Application by Elements Green Trent Limited: Great North Road Solar and Biodiversity Park (Application Reference: EN010162)

Submissions at Deadline 2

Appendix 1 of this letter provides an overview of the documents submitted by the Applicant at this Deadline. Table 1 comprises the application documents for which updated versions are being submitted and summarises how and why the document has been updated.

Great North Road Solar and
Biodiversity Park
Environmental Statement

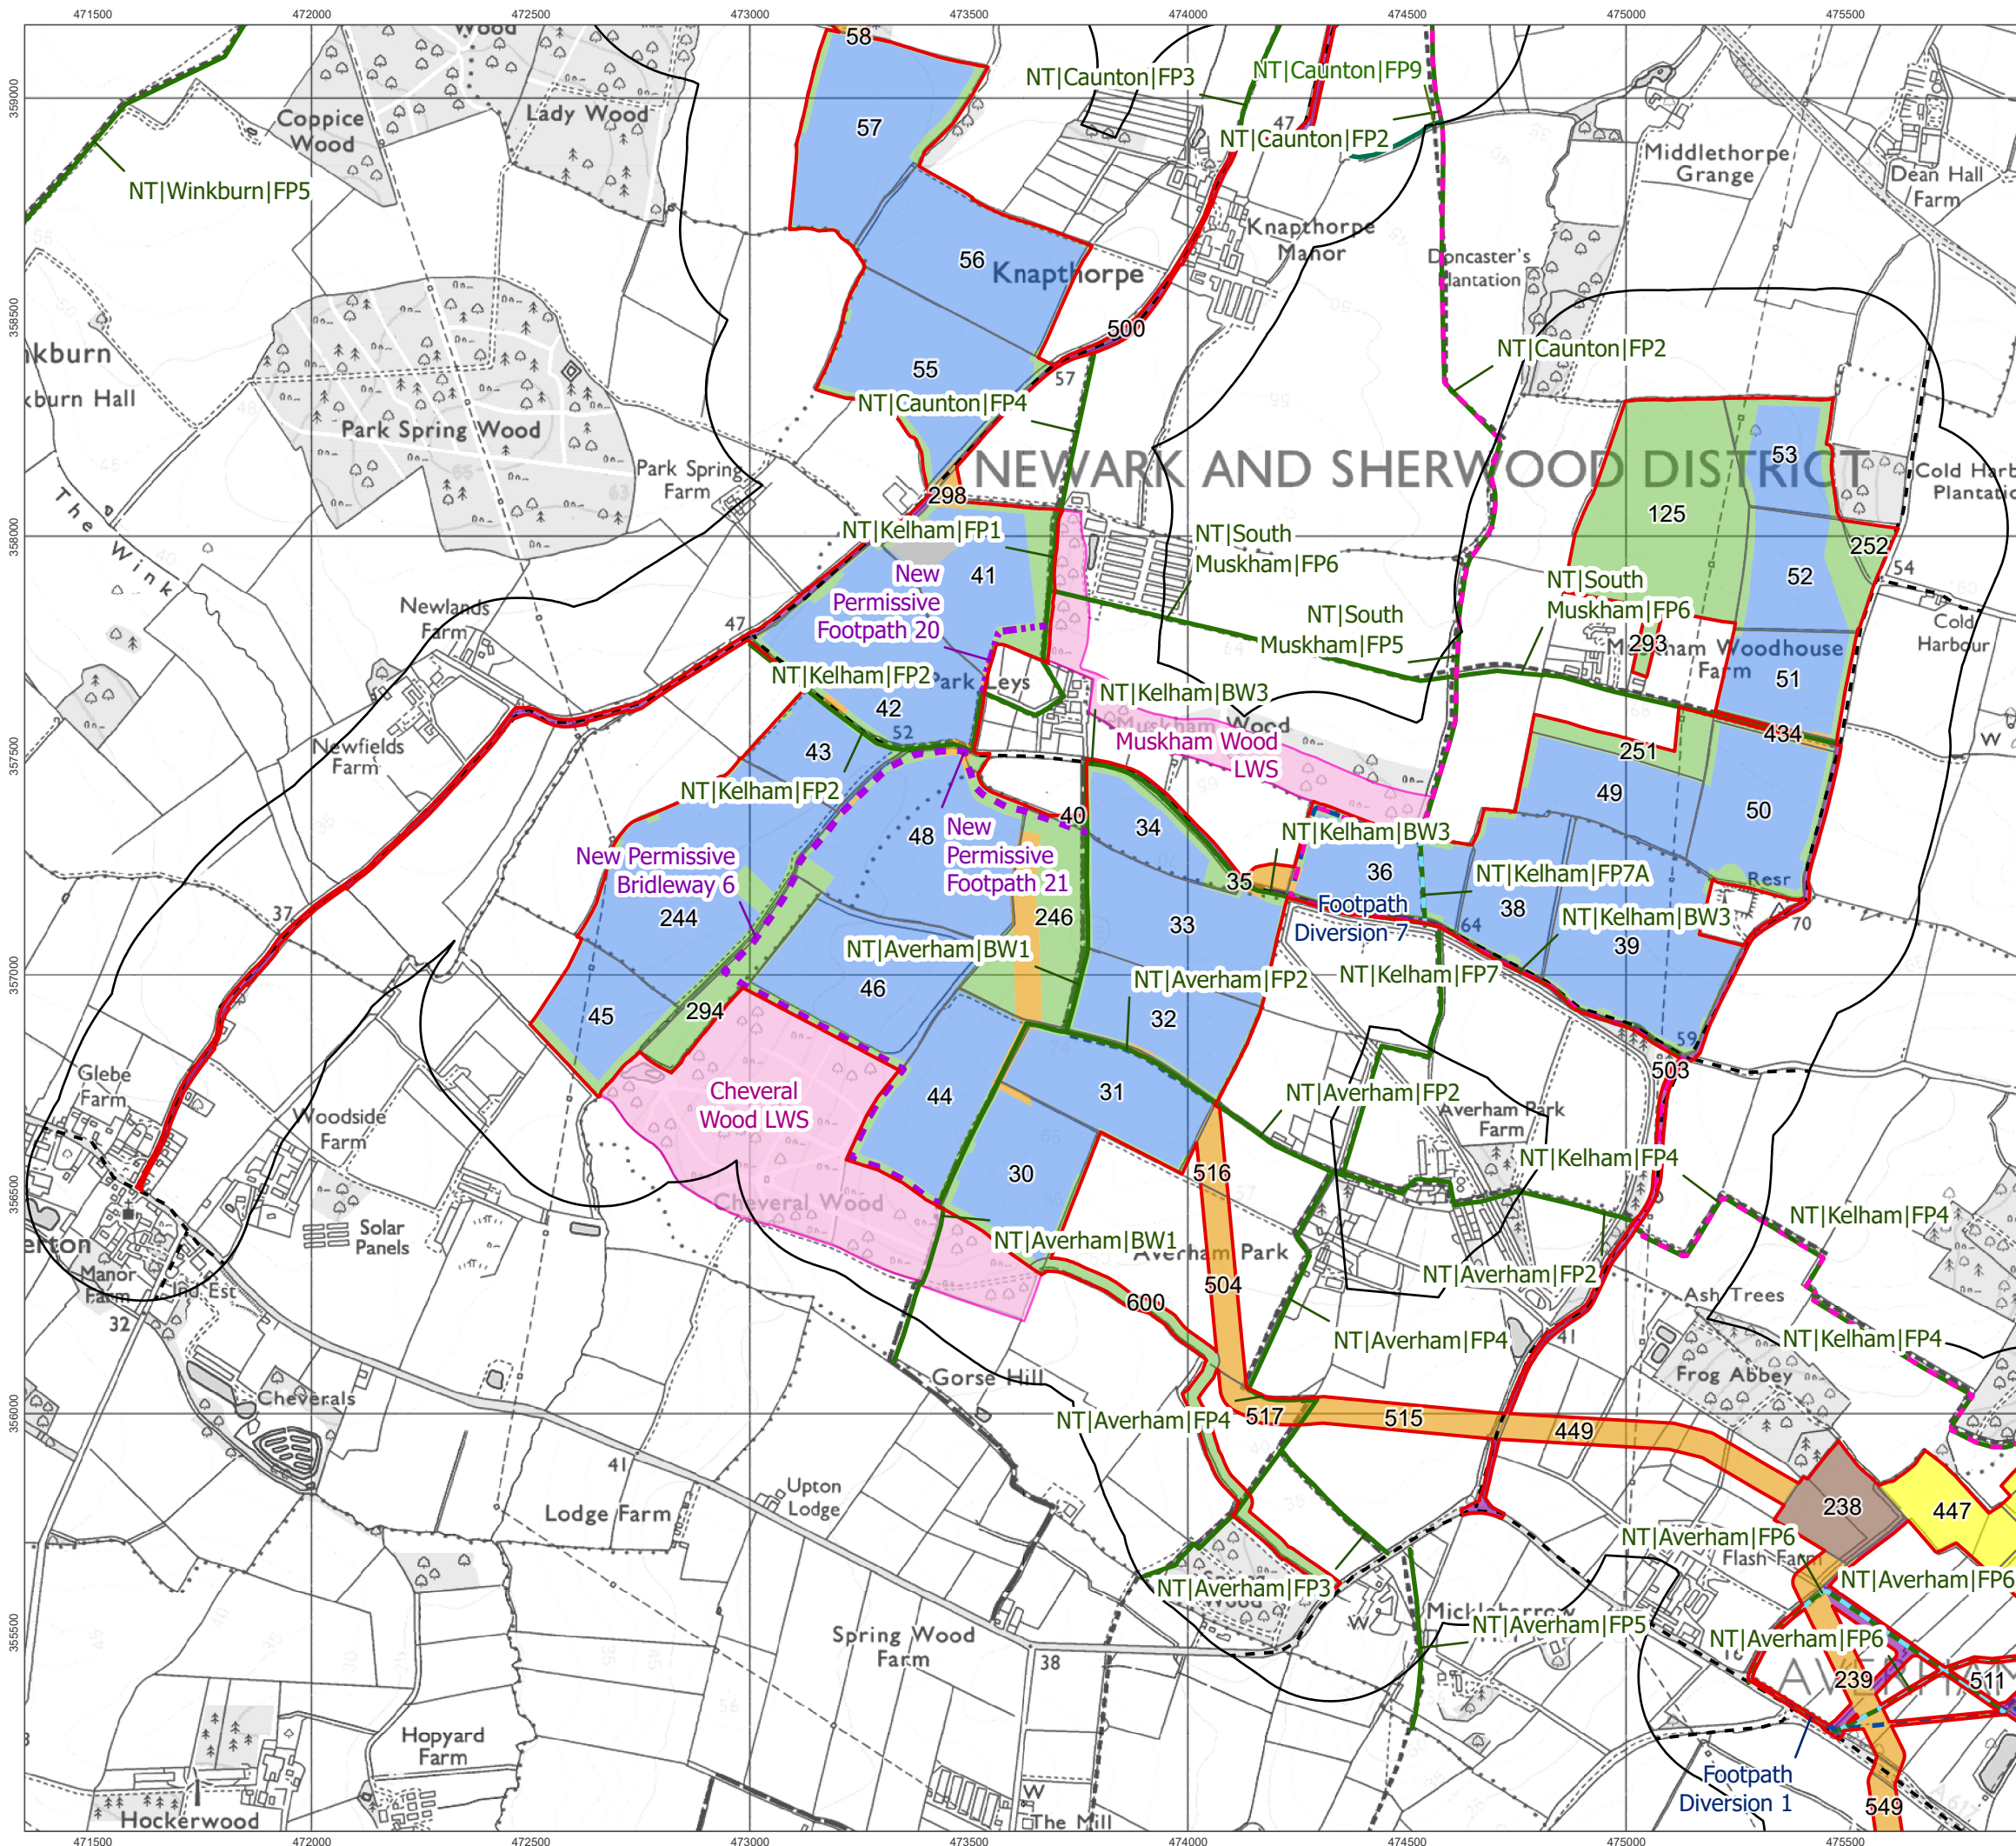
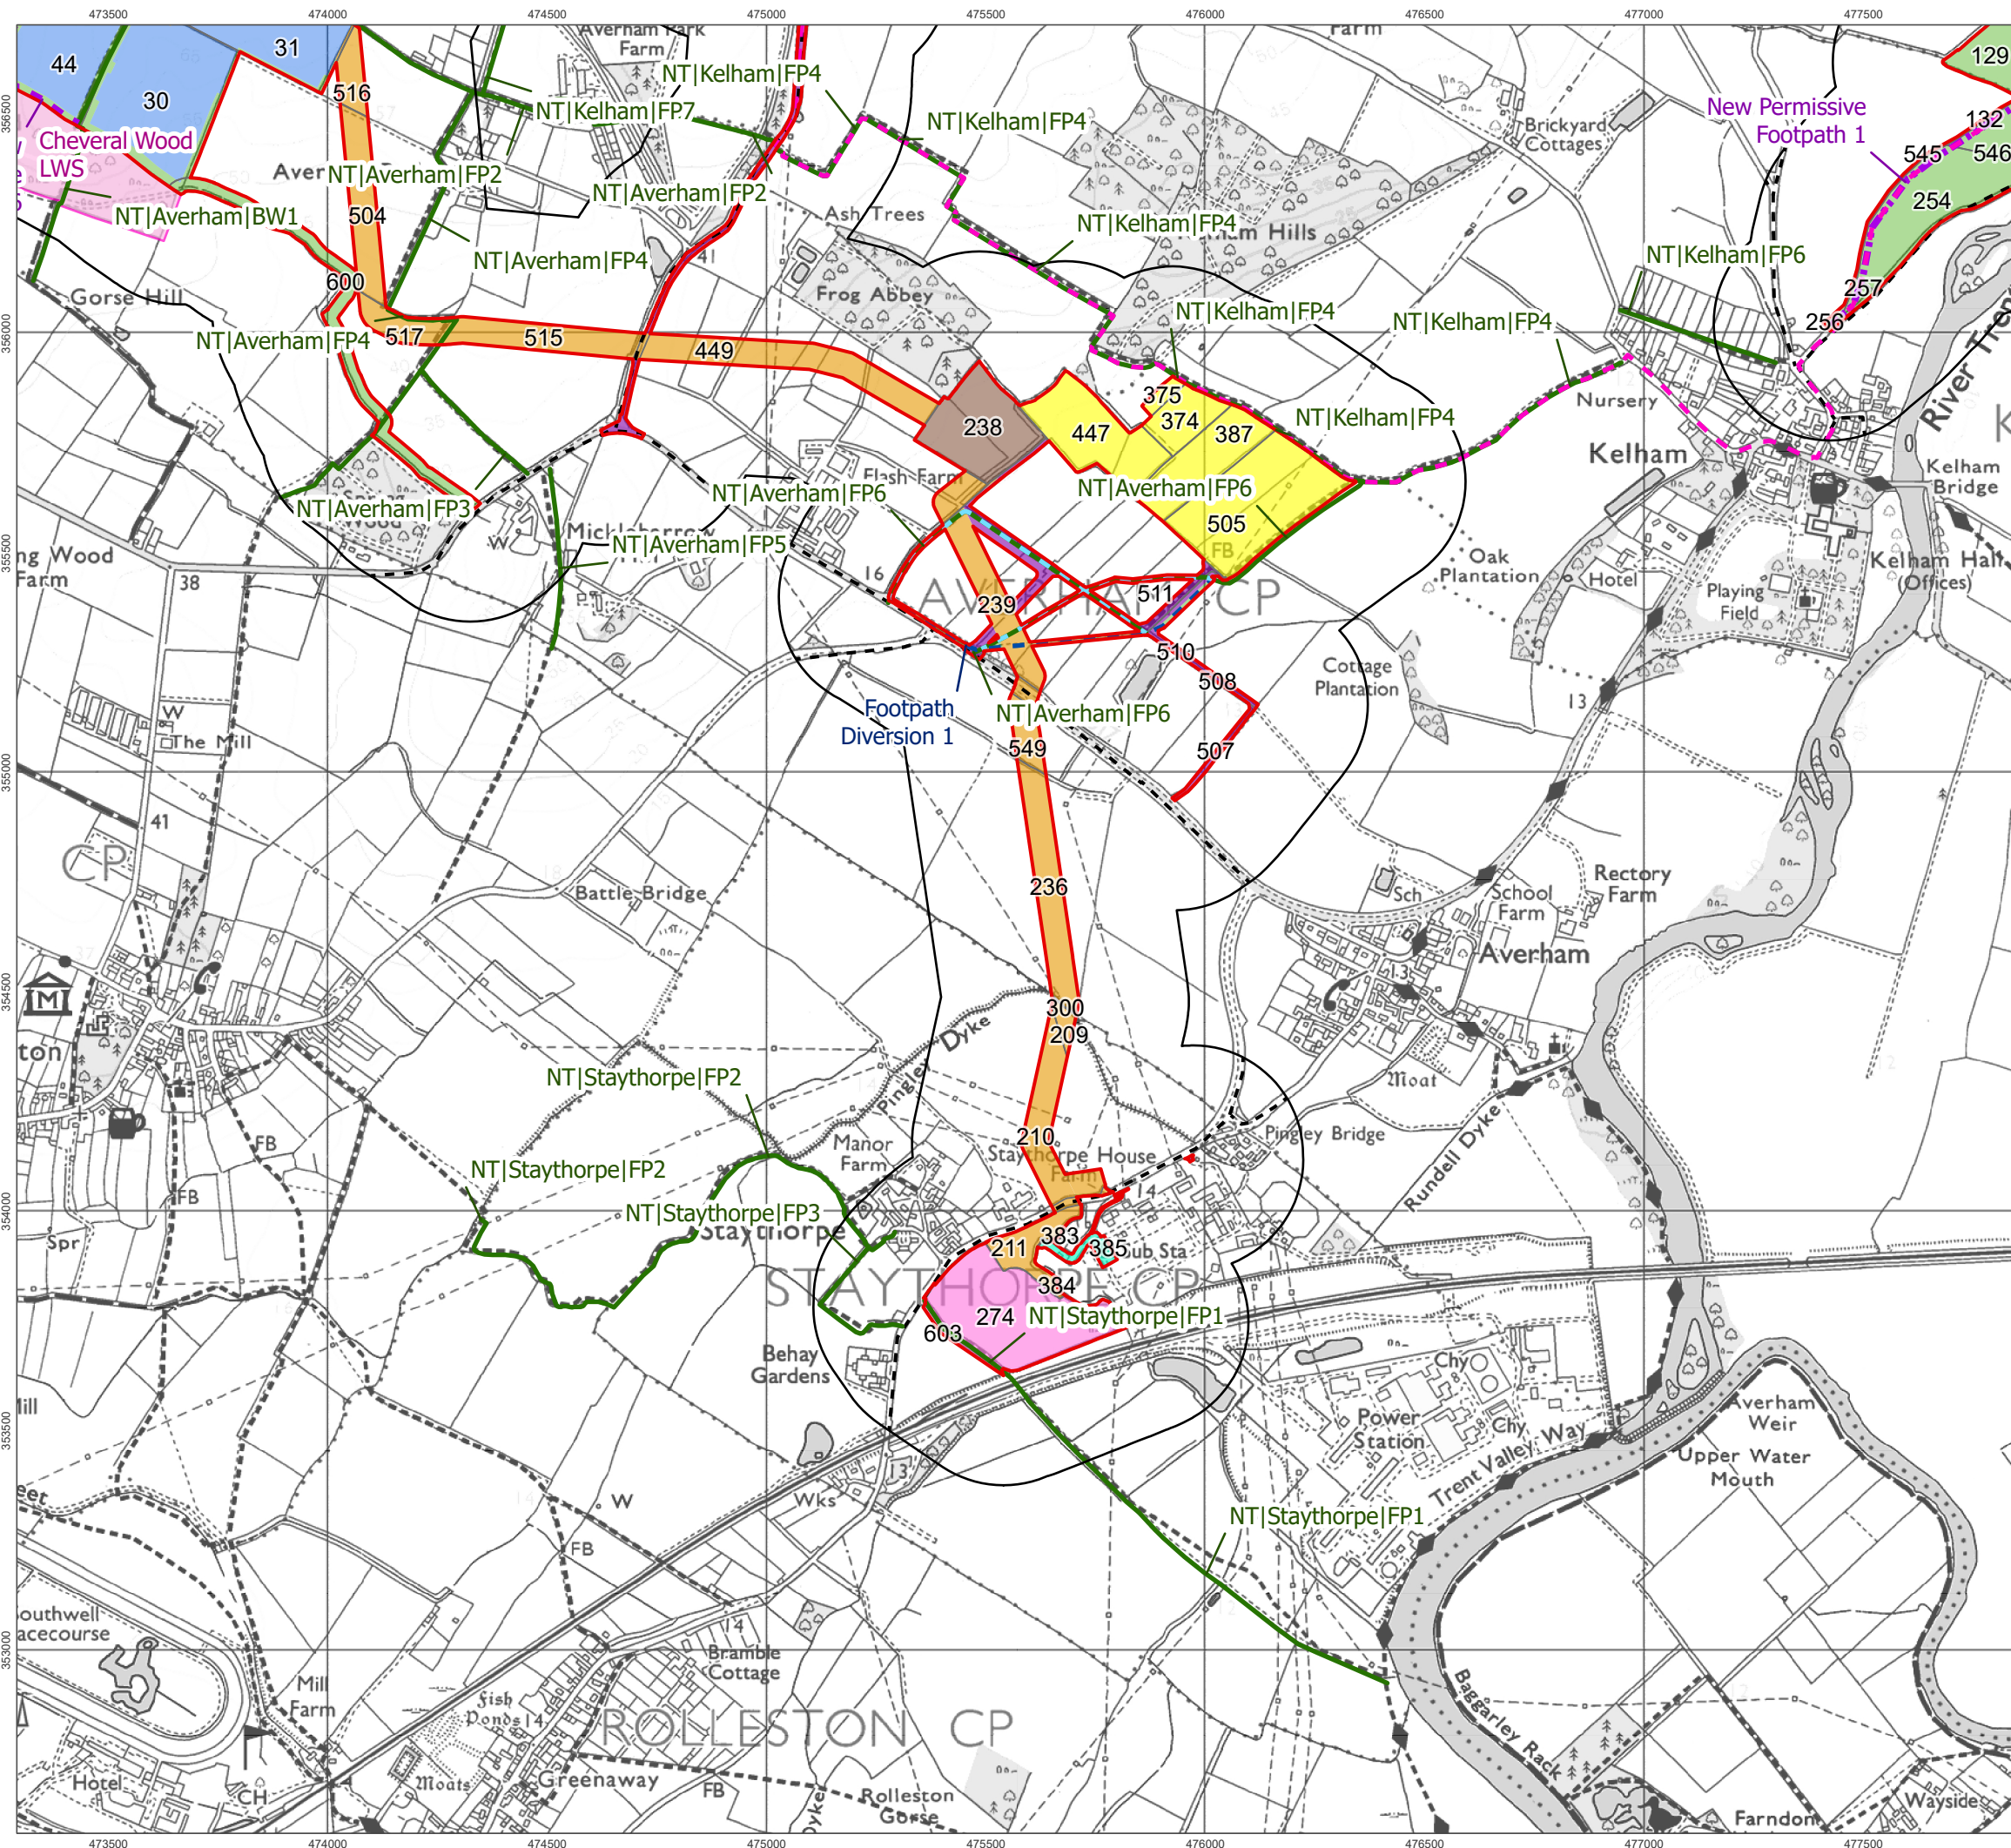
6.3.18B	3	ES Volume 3, Chapter 18 Recreation Figures 18.1 – 18.4	Updated Figure 18.3 Proposed Recreation Changes to remove part of Permissive Bridleway along

Doc Ref.	Revision Number	Document Name	Reason for Submission
			Bridleway Diversion for Construction and Decommissioning only route
6.4.2.1B	3	ES Volume 4, Appendix A2.1: Cumulative Assessment Stages 1 and 2	Update to reflect detailed feedback from NSDC on the list of cumulative schemes.
